# 12360 - North Penrith Stages 2B & 2C Development Application

## RESPONSE TO AGENCY SUBMISSIONS

NORTH PENRITH
STAGE 2B & 2C
WETLAND
SECTIONS

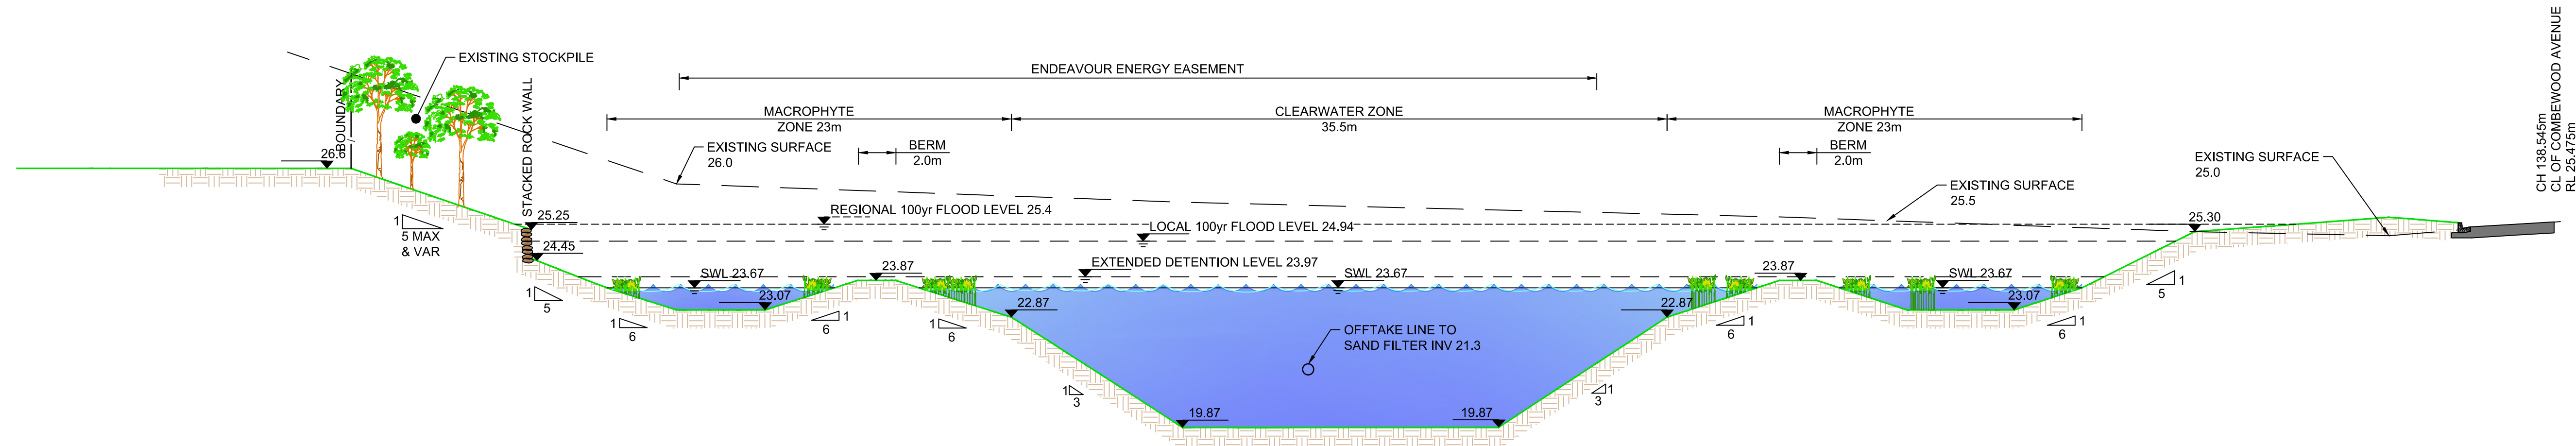
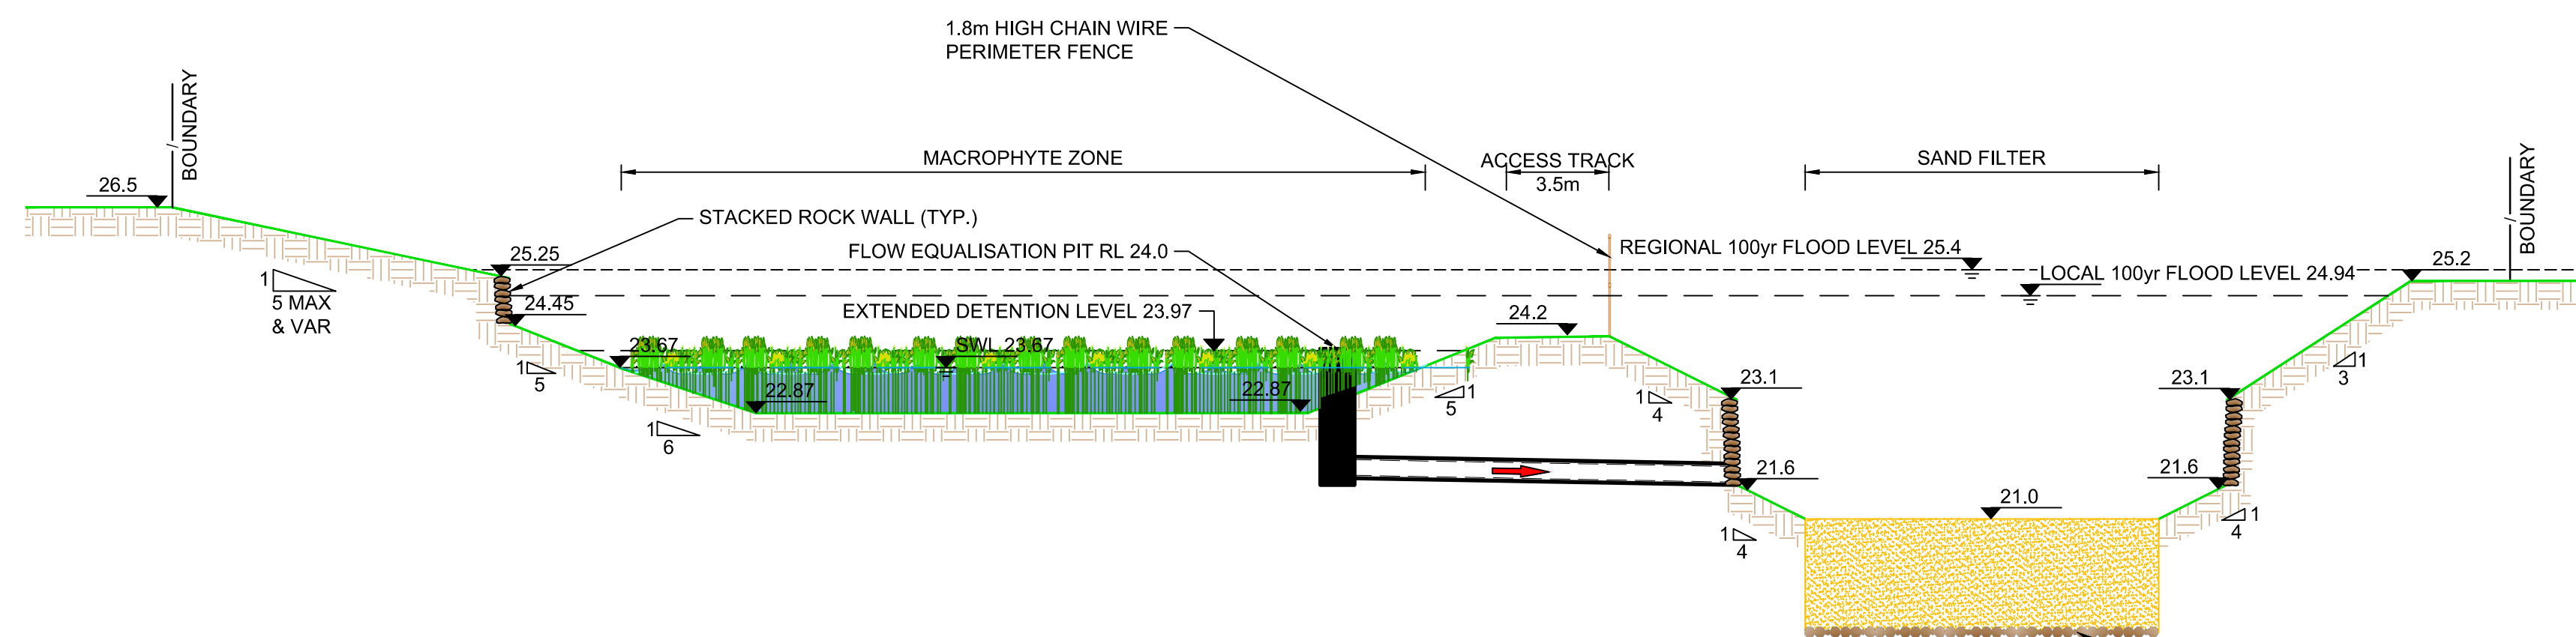
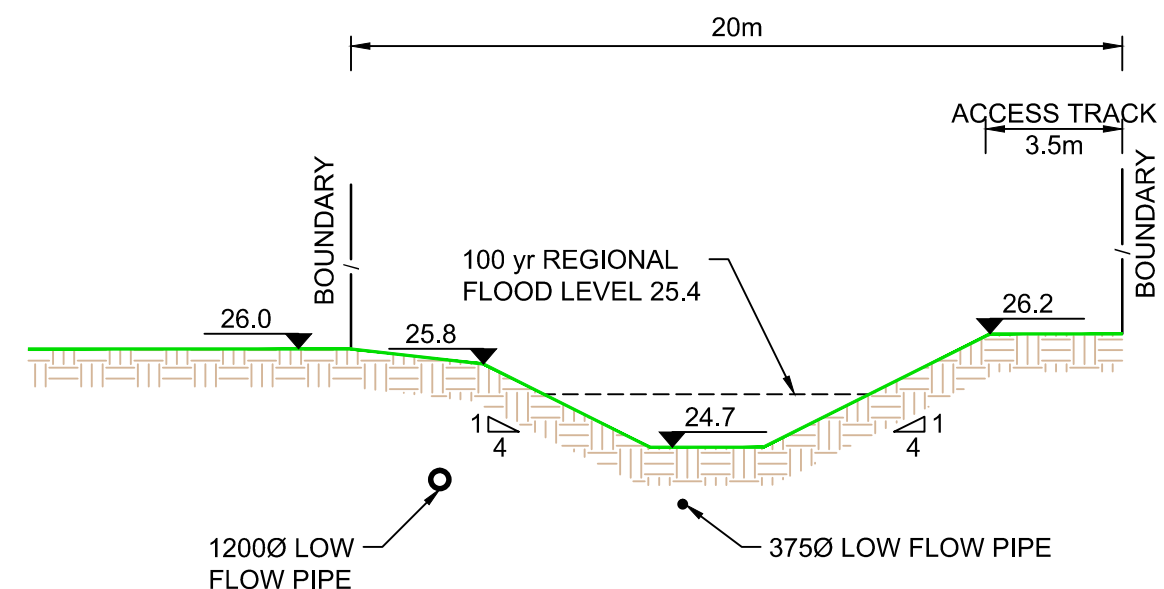
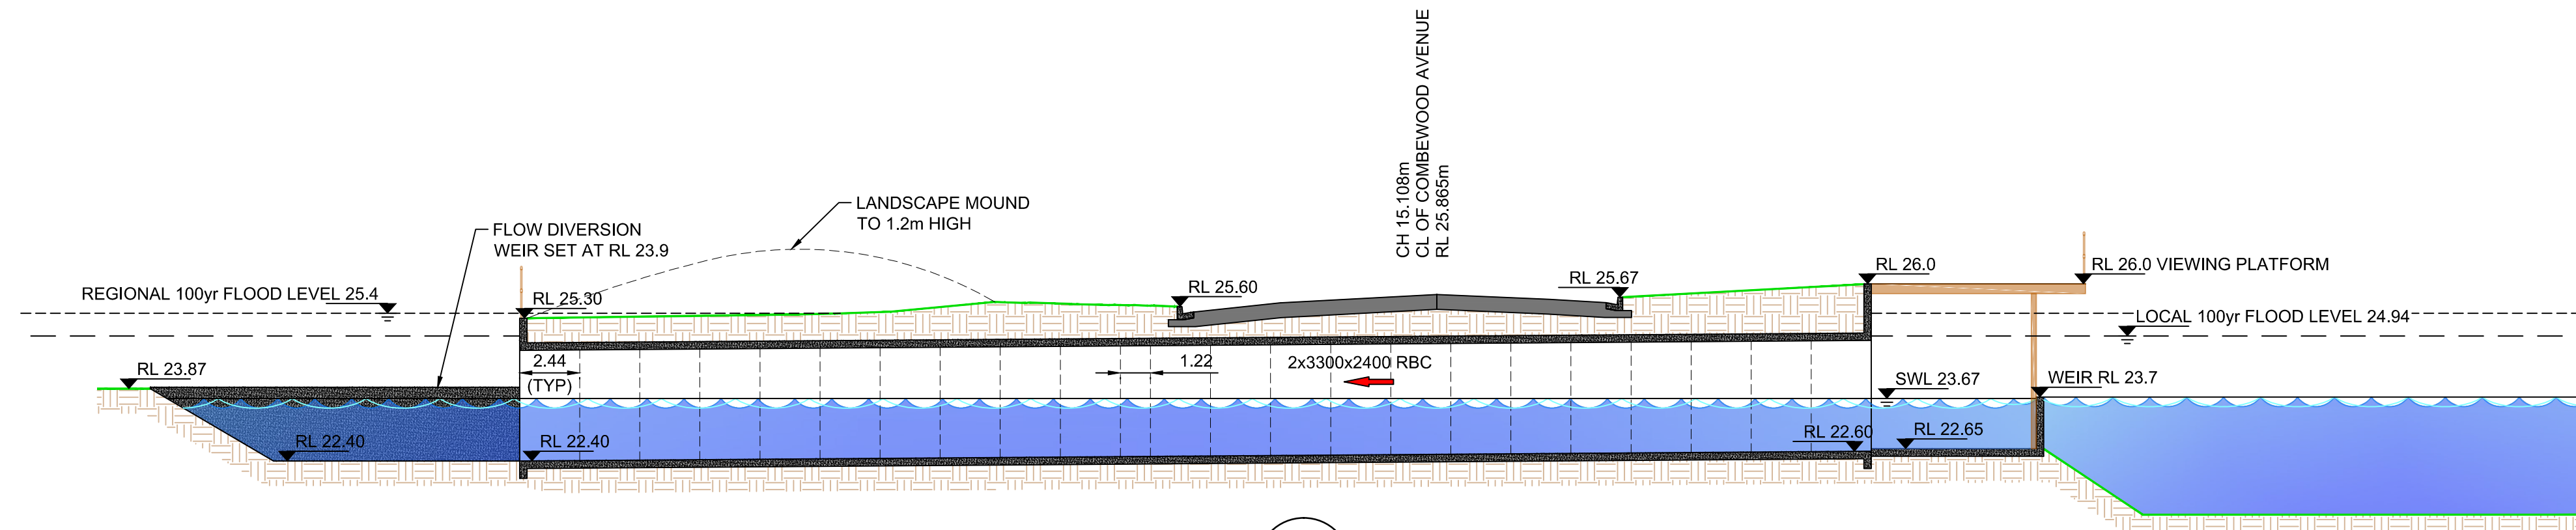
<ul style="list-style-type: none"> <li>The proposed channel is likely to have limited water quality benefits due to its design and lack of vegetation.</li> </ul>	<ul style="list-style-type: none"> <li>The central water feature and wetland have been designed as an integrated system to meet relevant water quality targets, as detailed and confirmed by the Water Cycle Management report.</li> </ul>
<ul style="list-style-type: none"> <li>There is likely to be an issue with sedimentation of the channel which will ultimately result in long term management issues with regard to algae growth. Detention ponds such as the one propose are commonly associated with algae management and unwanted vegetation management issues. The proposed water reticulation system and reliability of aerators will be critical to effective management of the canal and failure would likely result in management issues.</li> </ul>	<ul style="list-style-type: none"> <li>The inclusion of GPT's at all discharge points into the central water feature will reduce the sediment load entering the system. The system has been designed with best practice management principles and is considered to be a robust and functional system to manage algal growth.</li> </ul>

<ul style="list-style-type: none"> <li>The channel is also likely to act as a sediment basin; adequate access is essential for maintenance and to enable removal of sediment and other materials. Measures to remove floating litter and other waste material should also be factored into the detailed design stage and final construction.</li> </ul>	<ul style="list-style-type: none"> <li>The design has incorporated locations where floating litter can be collected collect and can be easily removed.</li> <li>Maintenance access has already been incorporated into the design and is detailed on drawing 9474/ DA18.</li> </ul>
<ul style="list-style-type: none"> <li>A detailed operational and management manual for the operation of the pumps, aerators, reticulation systems and management of the canal should be submitted to Council for approval before the handover of the assets.</li> </ul>	<ul style="list-style-type: none"> <li>An operational and management manual will form part of the CC documentation for the works. All manufacturer's operational and maintenance information will be provided to Council at the completion of works.</li> </ul>

<ul style="list-style-type: none"> <li>To ensure that the macrophyte zone functions efficiently, flows that pass through the vegetation must be evenly distributed. Dense vegetation growth is also required to dissipate flows and to support efficient filtration. Appropriate outlet structures are required to accommodate flow and water level variations and maximum velocities.</li> </ul>	<ul style="list-style-type: none"> <li>It is anticipated that velocity within the central water feature will likely be less than 2 m/s. The design already includes appropriate measures (flow split) to ensure the distribution of flows into the macrophyte zones. Outlet structures are already included in the design.</li> </ul>
<ul style="list-style-type: none"> <li>The wetland should be constructed to achieve a 72 hour detention time; the macrophyte zone outlet orifice must be sized accordingly. In order to demonstrate that adequate detention time is achieved within the wetland, monitoring should be undertaken to assess the performance of the wetland during the three year period prior to handover to Council. The wetland should also be constructed and managed to eliminate mosquito habitat and to encourage mosquito predators. Details of the proposed management strategies should also be provided in the operation and maintenance plan.</li> </ul>	<ul style="list-style-type: none"> <li>The design already includes a 72 hour detention time.</li> <li>The circulation of water through the wetland as part of the operation of the integrated system will assist in restricting mosquitos.</li> <li>Maintenance and operation is discussed in further detail below.</li> </ul>

<ul style="list-style-type: none"> <li>Adequate access should be provided to ensure that maintenance of the wetland can be undertaken. A detailed operation and maintenance plan should be developed and it should outline how operation and maintenance issues have been appropriately considered in the development of the WSUD strategy.</li> </ul>	<ul style="list-style-type: none"> <li>Maintenance access already forms part of the design and is detailed on drawing 9474/DA19.</li> <li>An operational and management manual will form part of the CC documentation for the works. All manufacturer's operational and maintenance information will be provided to Council at the completion of works.</li> </ul>
